Appendix 2 Highway Comments

Subject: FW: Proposed dwelling within garden of 39 Clitheroe Road Whalley BB7 9AD

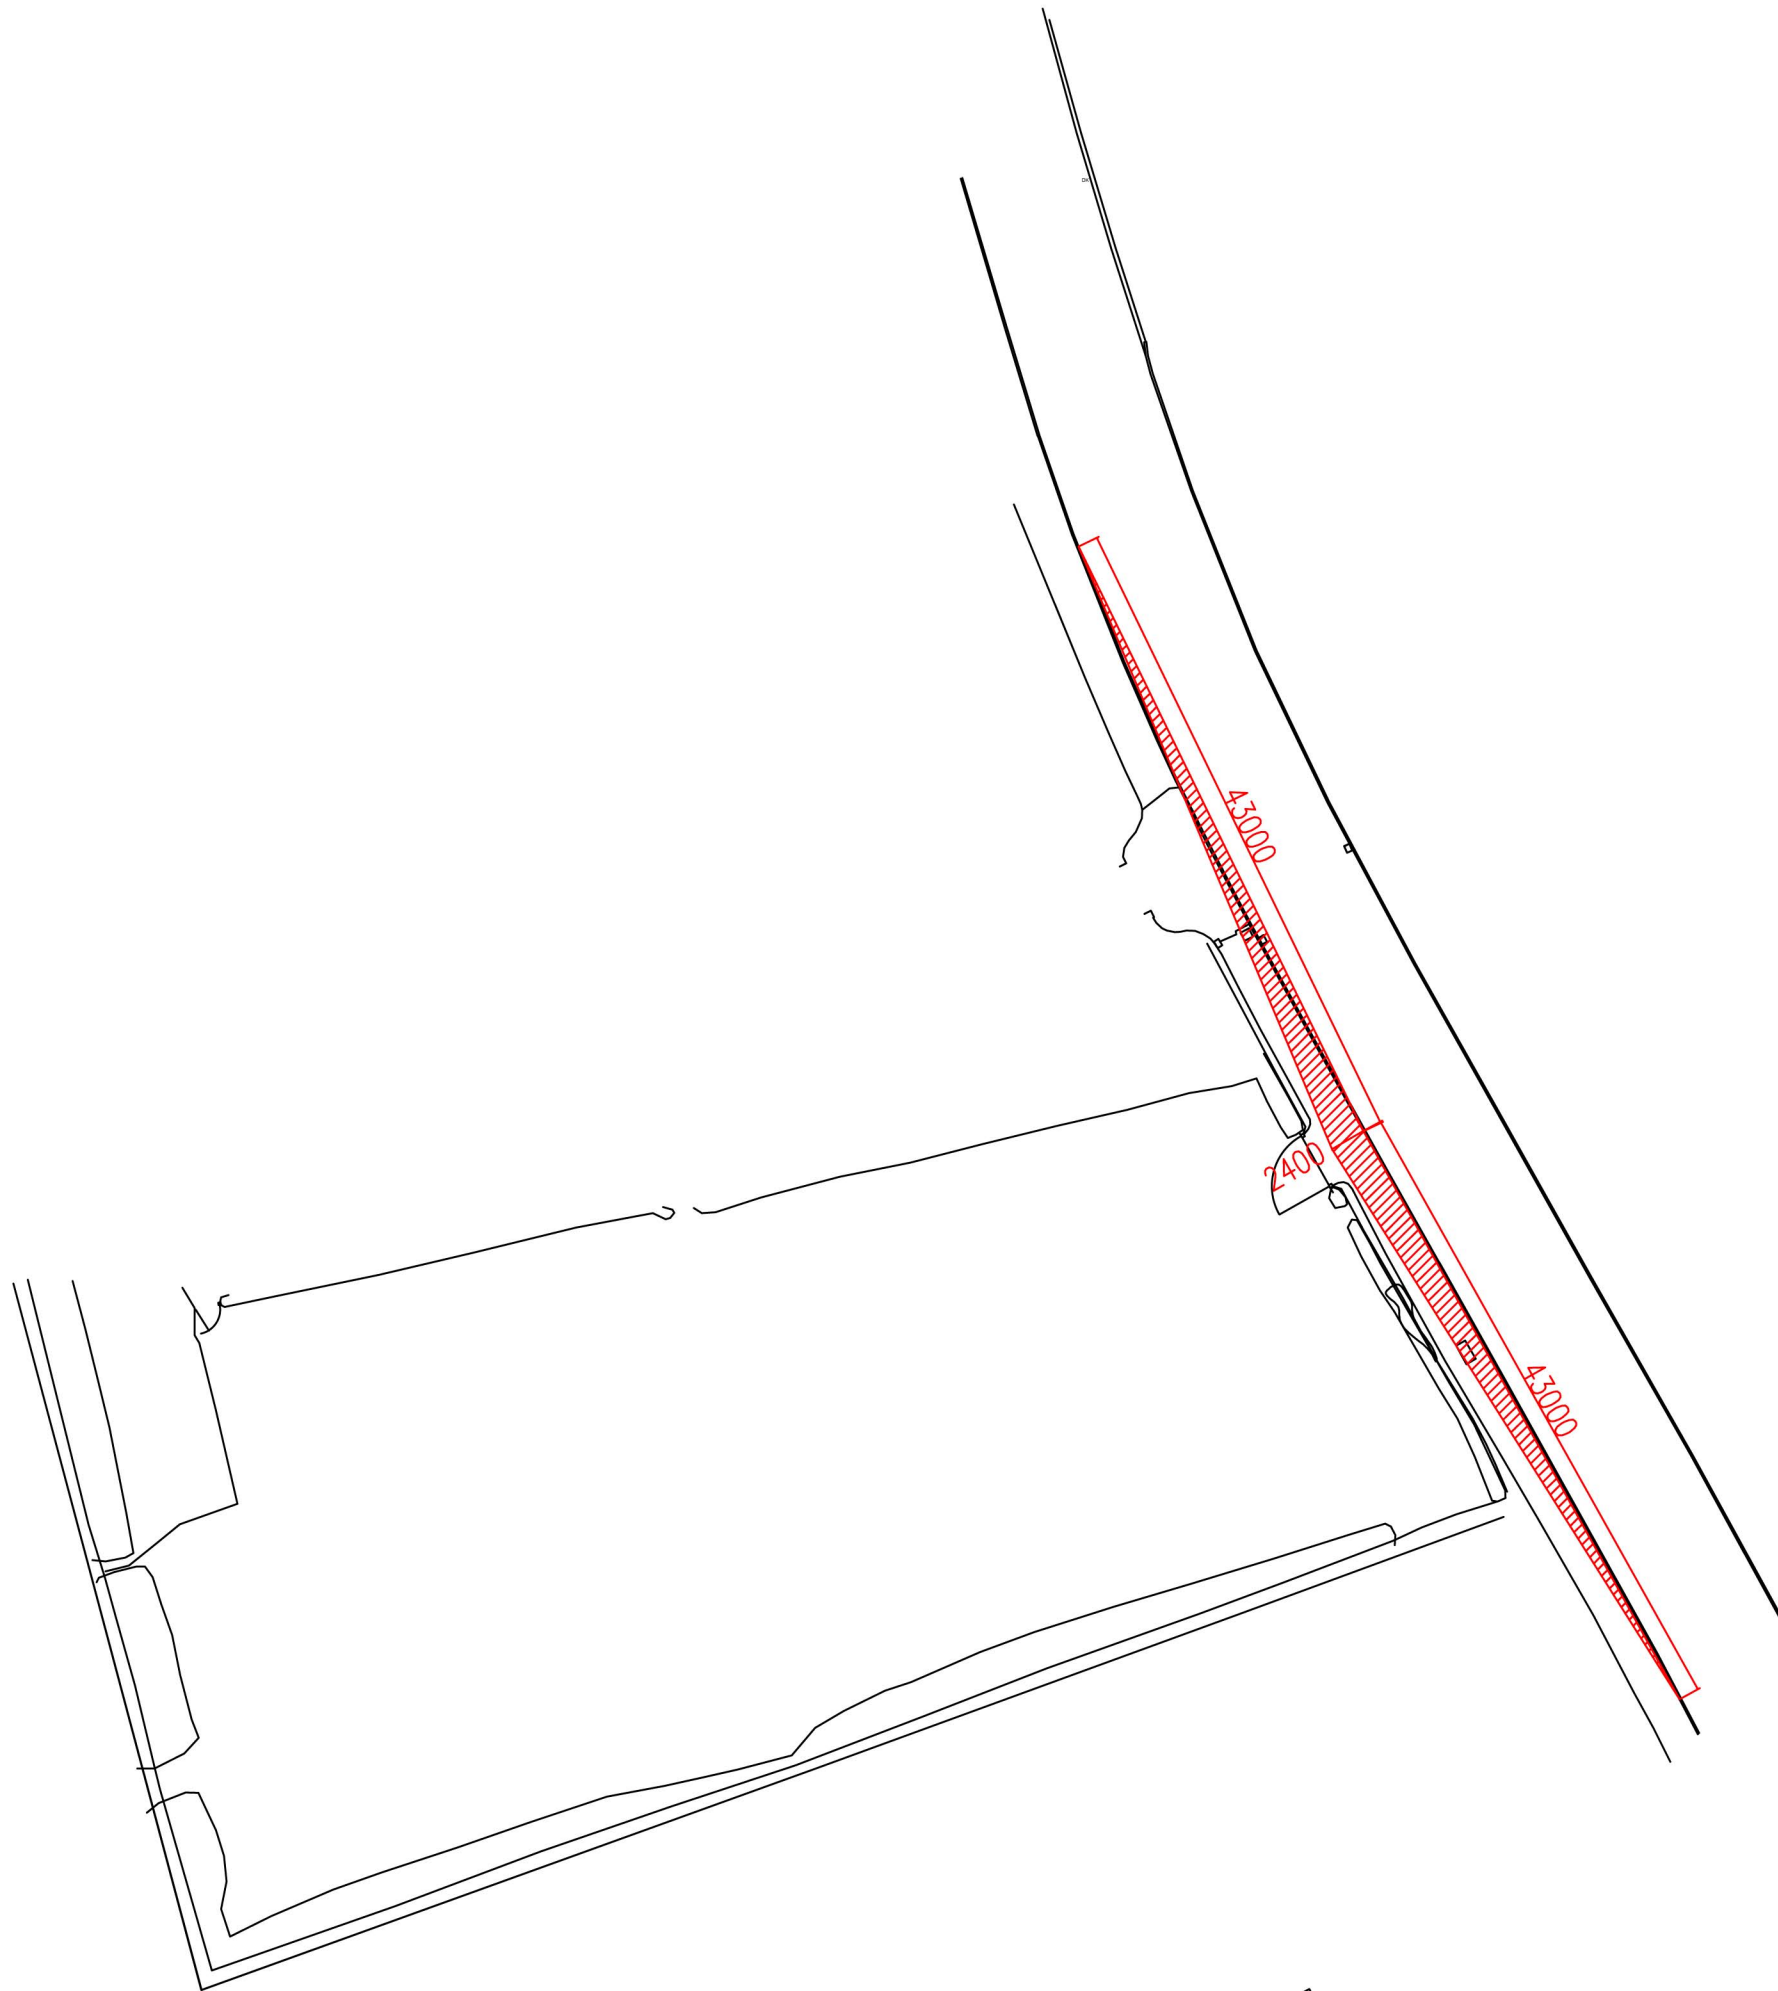
The position of the existing access is suitable for an access into the vacant property to serve a new dwelling. Visibility splays of 2.4m by 43m would be required here in each direction along Clitheroe Road and these appear to be achievable.

The width of the access should be appropriate for one car to pass. I would not ask for an access that could accommodate two cars passing each other at the access.

If it is intended to retain the gate here, it should be set back 6m from the edge of the carriageway in Clitheroe Road.
